# **A46 Newark Bypass**

**Scheme Number: TR010065**

## **Statement of Common Ground with Newark and Sherwood District Council 'NSDC'**

**February 2025**

- NOTES**
- THIS DRAWING IS TO BE READ IN CONJUNCTION WITH THE DRAFT DEVELOPMENT CONSENT ORDER AND ACCOMPANYING APPLICATION DOCUMENTATION. (TR010065/APP/3.1).

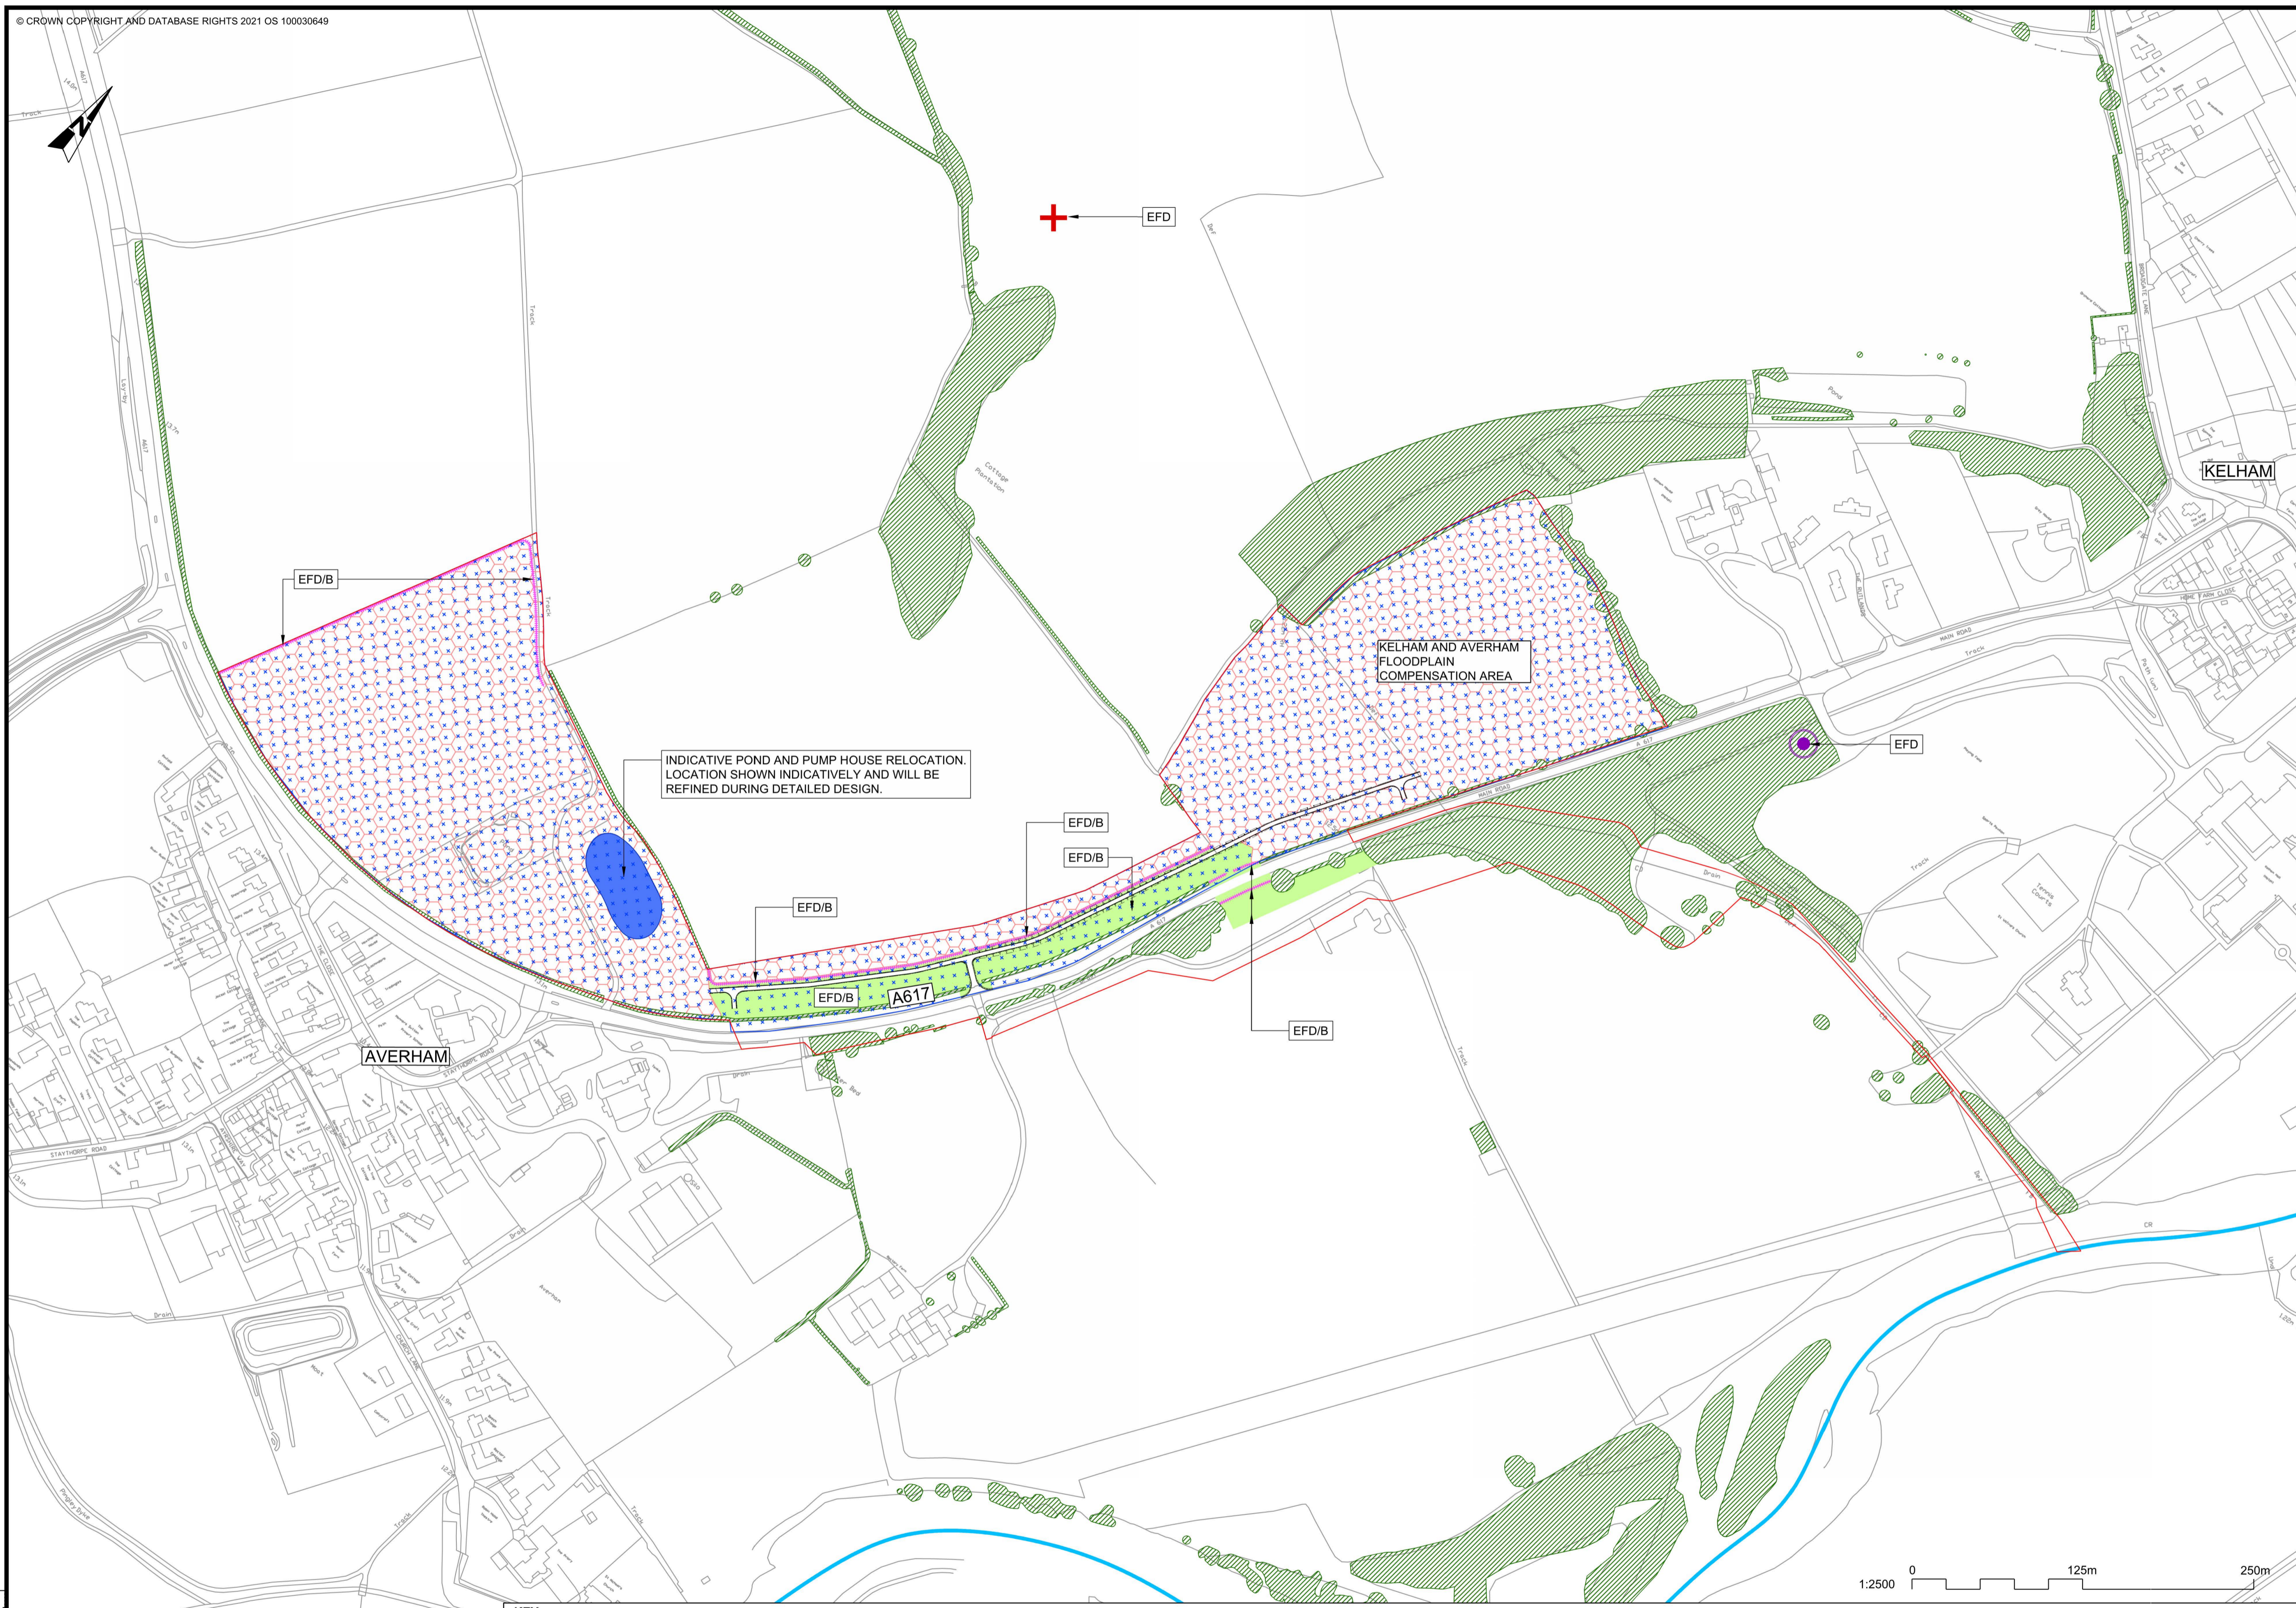
12.	Design (including justification for any flexibility being sought)	Chapter 2 The Scheme of the Environmental Statement [APP-046]  6.2 Environmental Statement - Figure 2.3 Environmental Masterplan [AS-026]	<b><u>Cattle Market flyover</u></b>  On the fly-through video the structure of the elevated over-pass at the Cattle Market junction appears as a stark and imposing concrete structure. This may be in part due to the animation which depicts it as being very bright in colour and therefore standing out vividly. The Council would want to understand proposals to ensure the visible impact of the final structure is minimised and/or mitigated as far as practicable.  03/02/2025 – Although this structure is now understood we still continue to raise concern with the impact the structure would have on the surrounding area.	Consideration has been given to the aesthetic finish of the structure during the design development to help to reduce the visual prominence of the structure and to reflect finishes on existing structures such as that of Smeaton's Arches just to the north of the new junction. Further details of these can be found within Chapter 2 The Scheme of the Environmental Statement [APP-046] and 6.2 Environmental Statement - Figure 2.3 Environmental Masterplan [AS-026].  Planting of trees and shrubs has also been considered and incorporated wherever feasible to help break up the visual mass of the structure, with planting softening the built form and aiding screening over time, particularly from properties such as those in Sandhills Park affording near distance views.  The assessment of landscape and visual effects and associated design and mitigation measures are described in 6.2 Environmental Statement - Figure 2.3 Environmental Masterplan [AS-026] and presented in 6.2 Environmental Statement - Figure 2.3 Environmental Masterplan [APP-026].  Part of the Detailed Design process will be to define the finish of the retaining walls forming the Cattle Market Flyover. This will be a masonry type façade and not a bare concrete finish.	Under Discussion	16/10/2024
